Appendix J to the Relevant Representations of Natural England

Onshore Ecology

The construction and operation of the Five Estuaries Offshore Wind Farm located approximately 57km from the Essex Coast in the Southern North Sea.

Planning Inspectorate Reference EN010115

DRAWING NUMBER: **1**

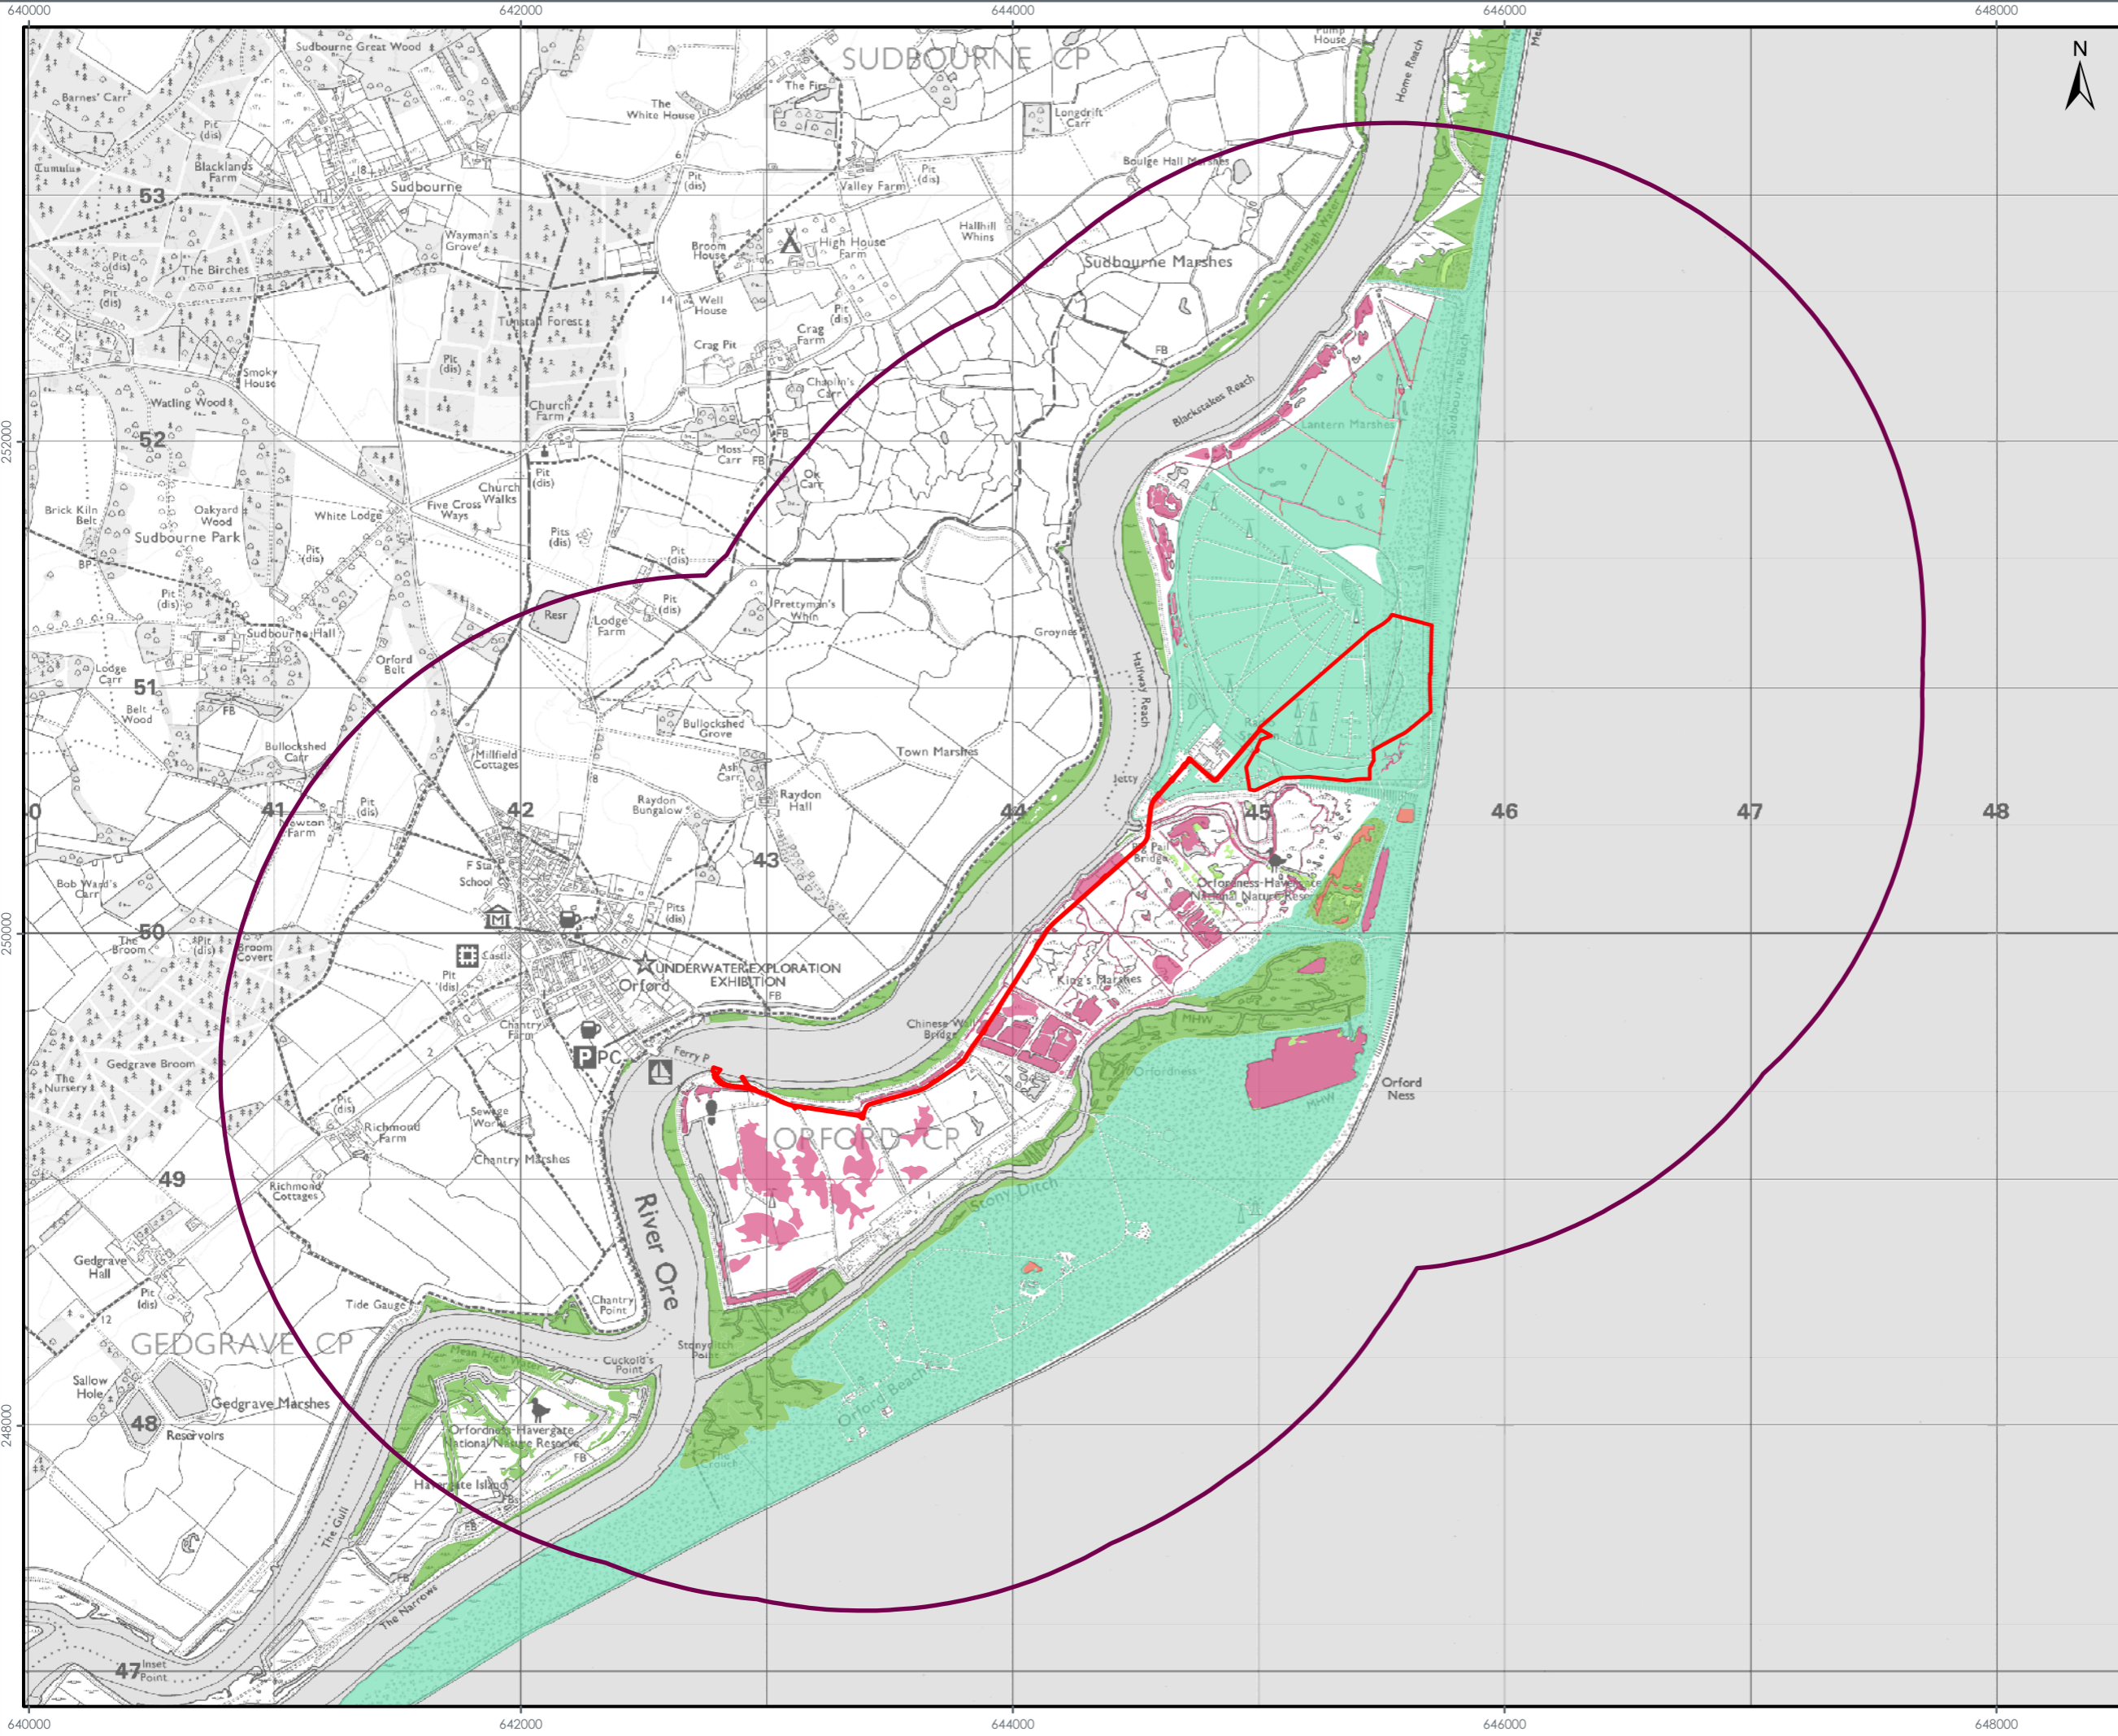
Natural England's Key Considerations	Natural England's Advice				
Relevant and Written Representations	NE Ref	Ref	Comment	Recommendation	Risk (RAG)
	J25	APP-225, Table 4.16	Natural England is unable to agree with the HRA conclusions for coastal lagoons at Orfordness-Shingle Street SAC. The HRA has not considered whether the presence of the predator exclusion fence over the lifetime of the project could interfere with overtopping and sediment transfer processes, which may in turn alter the flora and fauna in the saline lagoons present within the compensation area for LBBG. Furthermore, climate change-related impacts (including to water level and coastal stability) need to be considered over the lifetime of the project.	Natural England advises that the Applicant needs to fully consider all potential impacts to the coastal lagoons within the Orford Ness LBBG compensation site, over the lifetime of the project and the HRA should be updated accordingly.

DRAWING NUMBER: 2

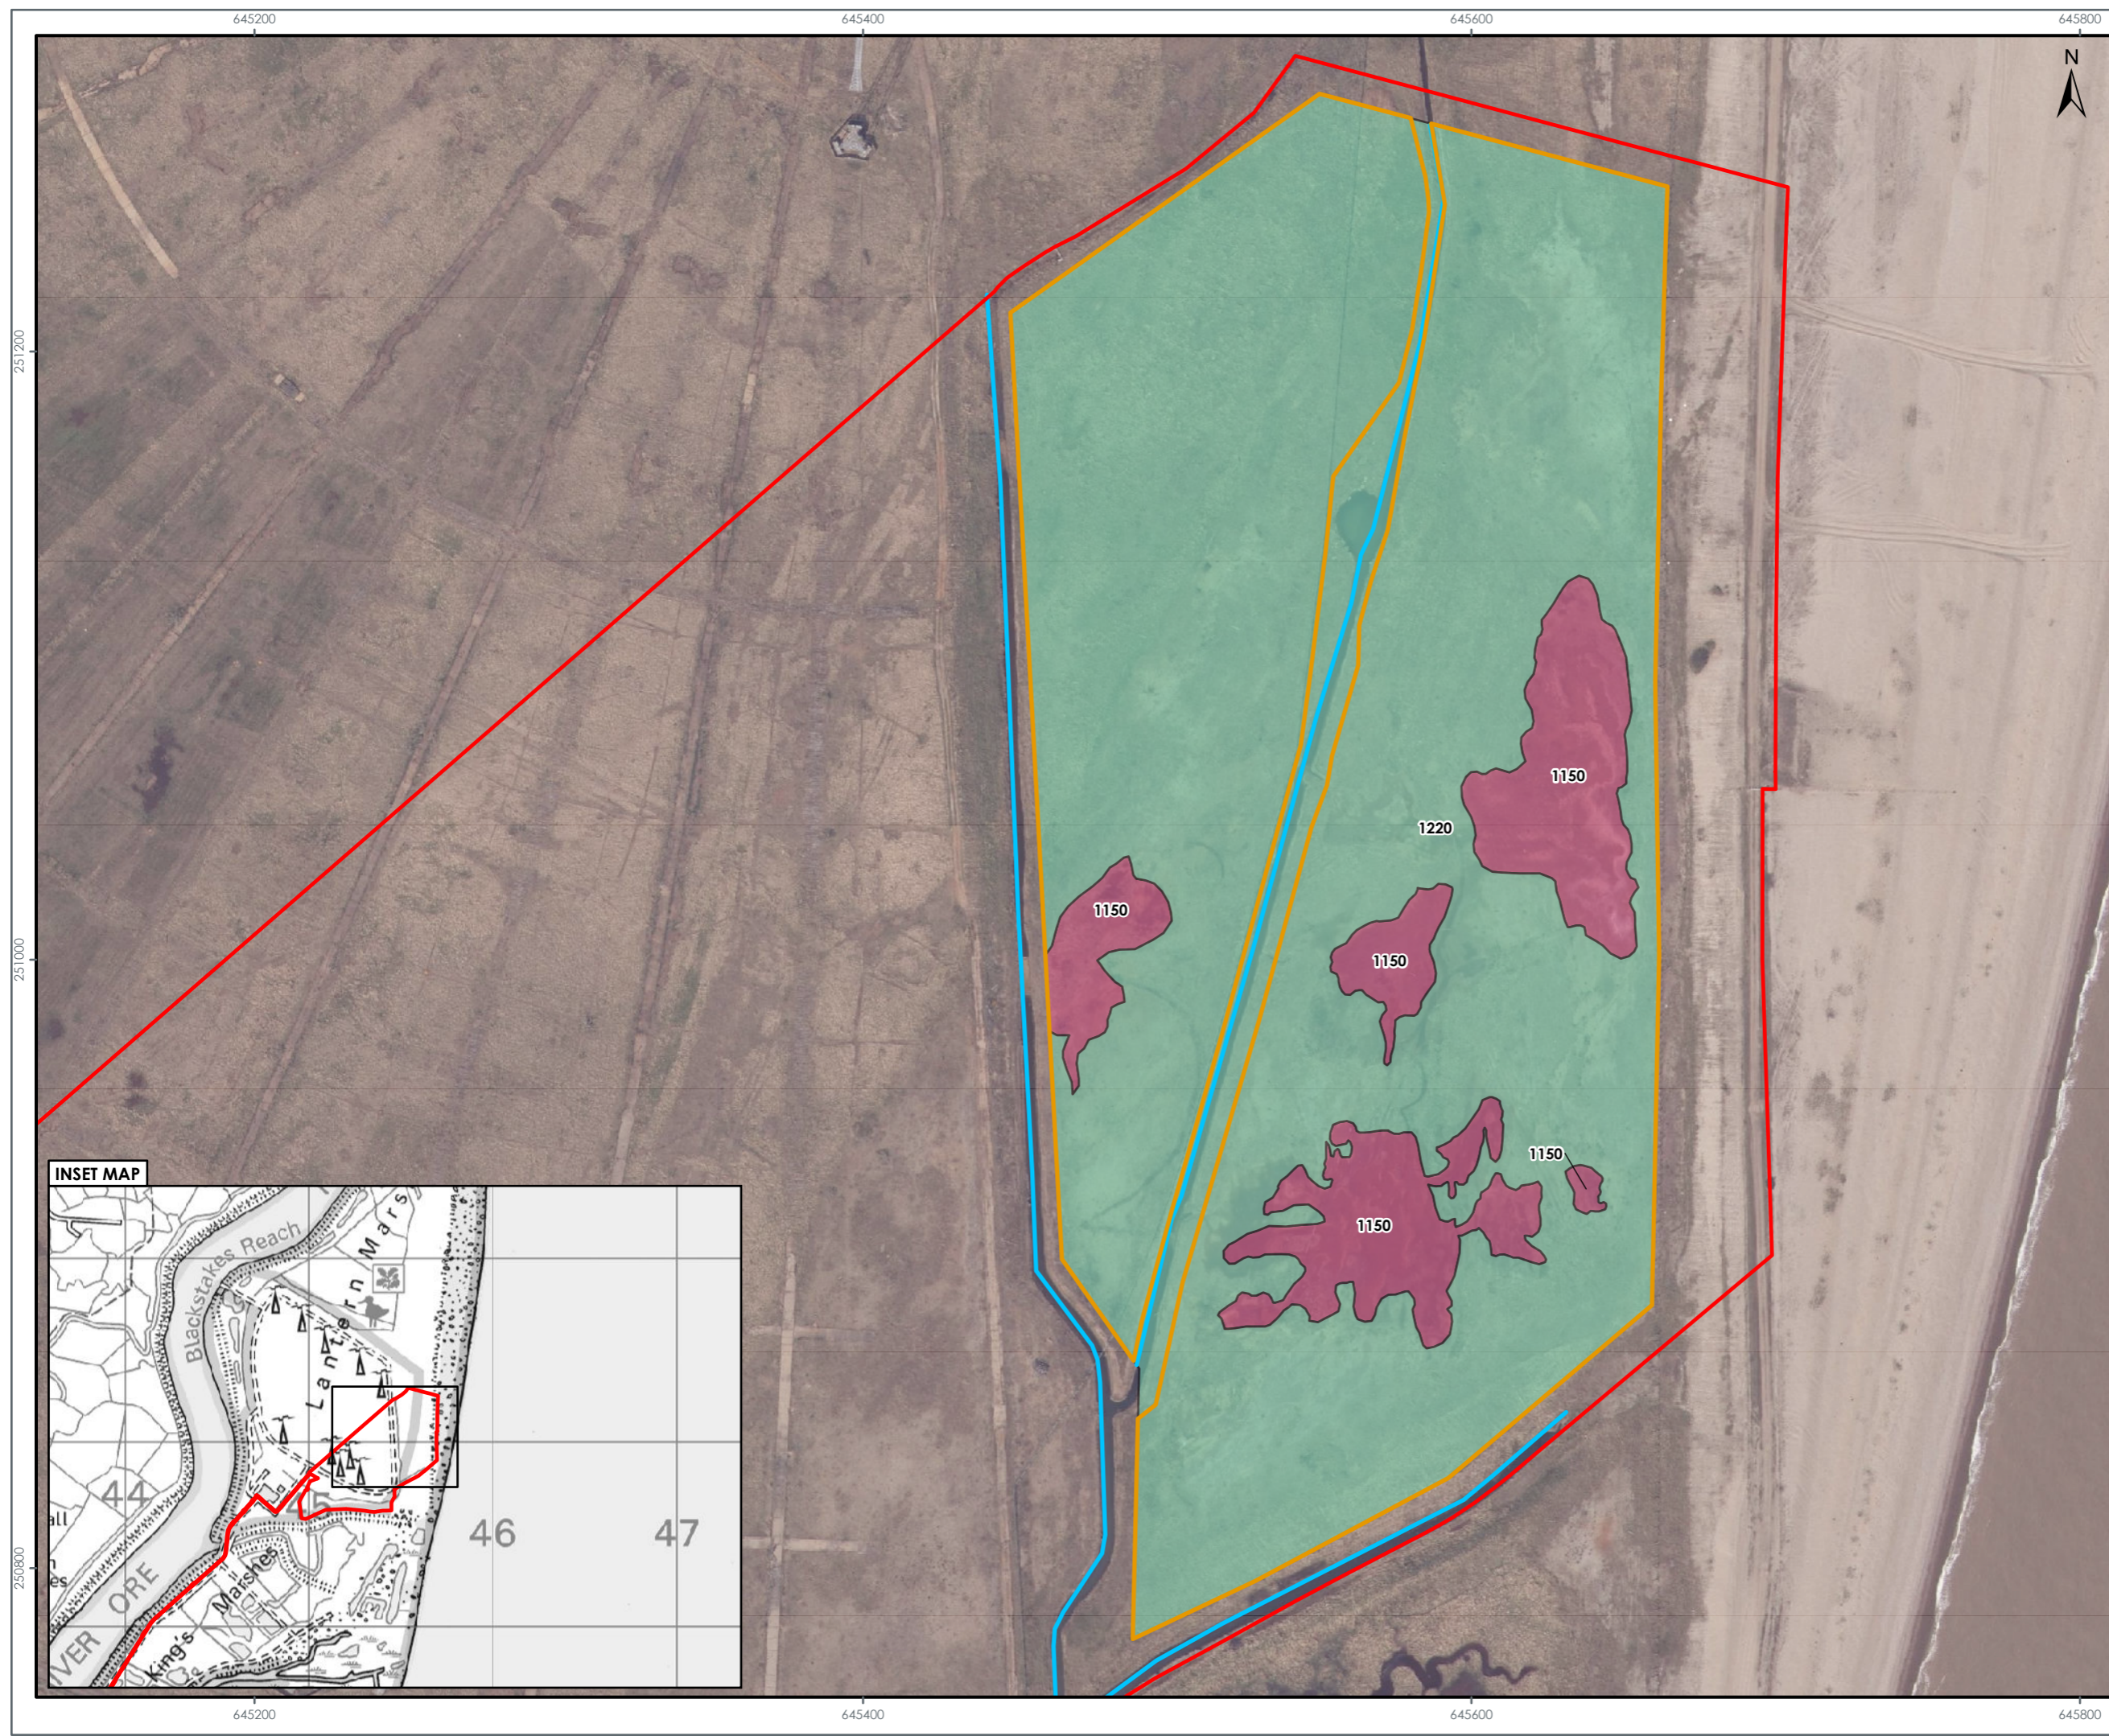
Assessment Conclusions	J24	APP-225, Table 4.18	<p>Natural England does not agree with the assessment conclusions for the LBBG compensation site on Orford Ness with regards to impacts to the shingle morphology due to construction/removal and maintenance of the predator</p>	<p>Natural England advises that the Applicant needs to establish a more robust baseline in terms of the shingle morphology and habitats/species present at the proposed compensation site prior to</p>

Natural England's Key Considerations	Natural England's Advice				
Relevant and Written Representations	NE Ref	Ref	Comment	Recommendation	Risk (RAG)
			<p>exclusion fencing. It is stated that "<i>the Project could change the shingle morphology along the fence alignment [if excavated material is not returned to its original location].</i>" We advise that recoverability of damaged shingle is slow, particularly where it is more static and active geomorphological processes no longer have a major role in shaping the shingle morphology. In addition, machinery and plant will need to be transported from the boat landing to the site which will cause compaction of the substrate and physical damage to vegetation (c. 0.13ha). Undisturbed vegetated shingle communities are dependent on a precise matrix of coarse sediment infilled with fine sediment, which in many cases have developed over long periods of time. These communities could be damaged through the installation of fence posts. Furthermore, unless conducted sensitively and in line with a mitigation strategy, vegetation control could result in a permanent loss of the Annex I habitat, whilst repeated damage is likely to occur through regular maintenance checks and works.</p>	<p>determination, in order to fully consider and assess impacts to the site through installation/removal and maintenance of predator fencing, Future site evolution should also be considered fully in terms of climate change and the sensitivities of the priority habitats.</p>
